Transport & Highways Appraisal

Reference	1131/APP/2026/1022
Location	CHANDIGRAH SUMMERHOUSE LANE HAREFIELD
Proposal	Variation of Condition 2 (Approved Plans) of planning permission ref. 1131/APP/2025/2465, dated 11-11-2025 (Variation of Conditions 2 (Approved Plans), 3 (Materials), 6 (Tree Protection), 8 (Landscaping) and 9 (Step Free Access) and removal of Conditions 4 (Obscure Glazing) and 5 (Access to Flat Roof) of appeal decision ref. APP/R5510/W/24/3341154 (Hillingdon Council ref. 1131/APP/2023/3251) dated 21-02-2025 (Erection of 4 dwellings following the demolition of the existing equestrian storage buildings on land adjacent to Chandigrah) to amend the roof forms from flat to pitched, amend the choice of materials, and to provide additional parking provision.) to alter the roof structure and fenestration arrangements.
Case Officer	Sally Robbins
Recommendation	GRANT (subject to the two conditions listed below)

LANDSCAPE PLAN

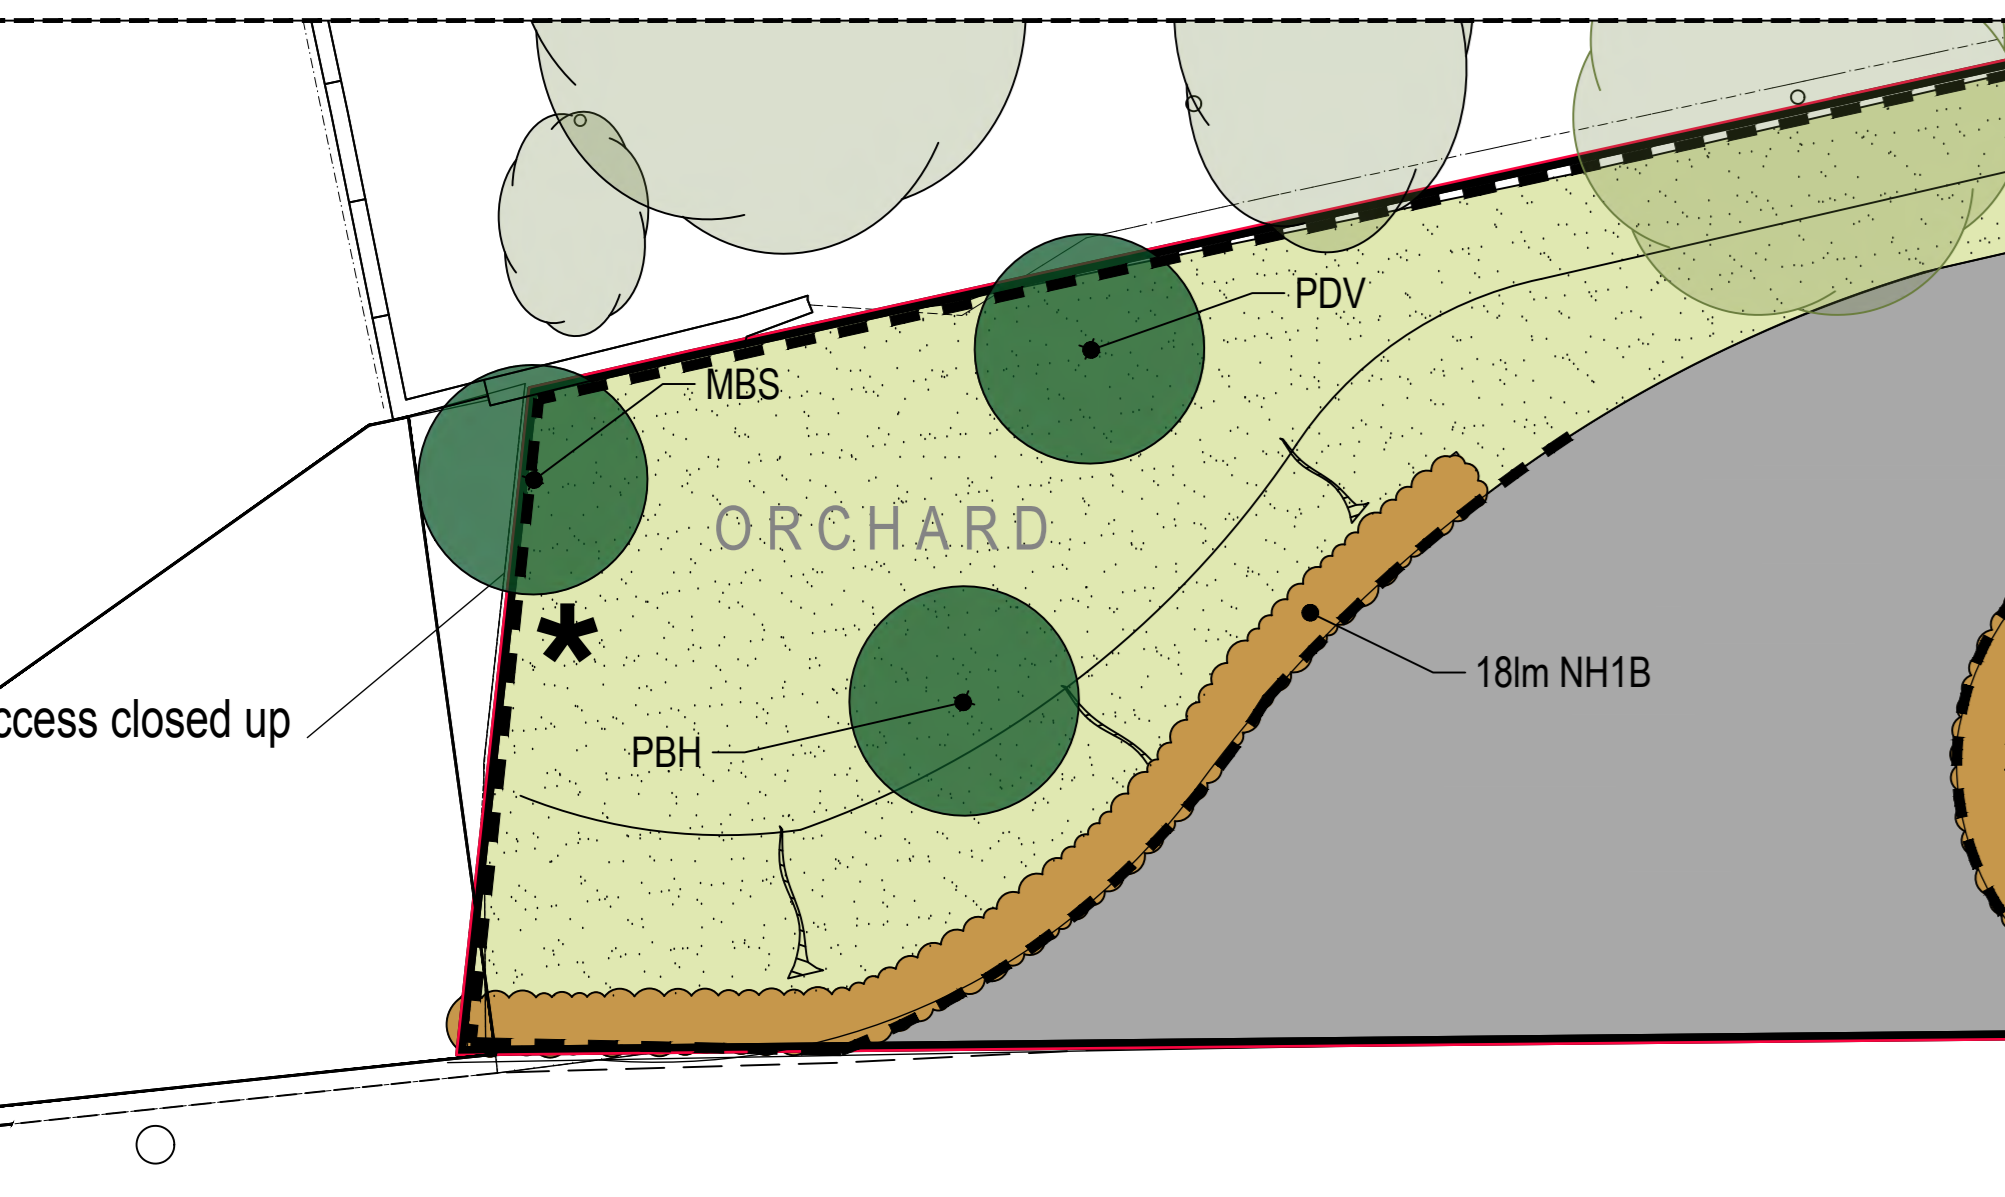
In line with the London Plan (2021), within the final parking quantum there is a requirement for a minimum 20% 'active' EVCP provision with all remaining spaces (80%) being designated as 'passive' provisions. In this case each unit should incorporate 1 'active' & 1 'passive' space to future proof for anticipated demand. **The applicant confirms the provision of 1 'active' space per unit whilst the absence of an equivalent 'passive' provision should be remedied by way of planning condition.**

In terms of cycle parking, there would be a requirement to provide 2 secure and accessible space per unit. This quantum suitably located to the side or rear of each new build is to be provided which conforms to the standard.

In order to conform to accepted 'waste collection distances' from the highway, the bin storage area/collection point should be positioned within 10m of a refuse vehicle. A generic bin store for all 4 units is to be positioned in proximity of the revised access/turning area located adjacent to the public roadway. Residents would therefore be expected to position their refuse within this enclosure if they wish for their refuse to be collected. There are no further observations.
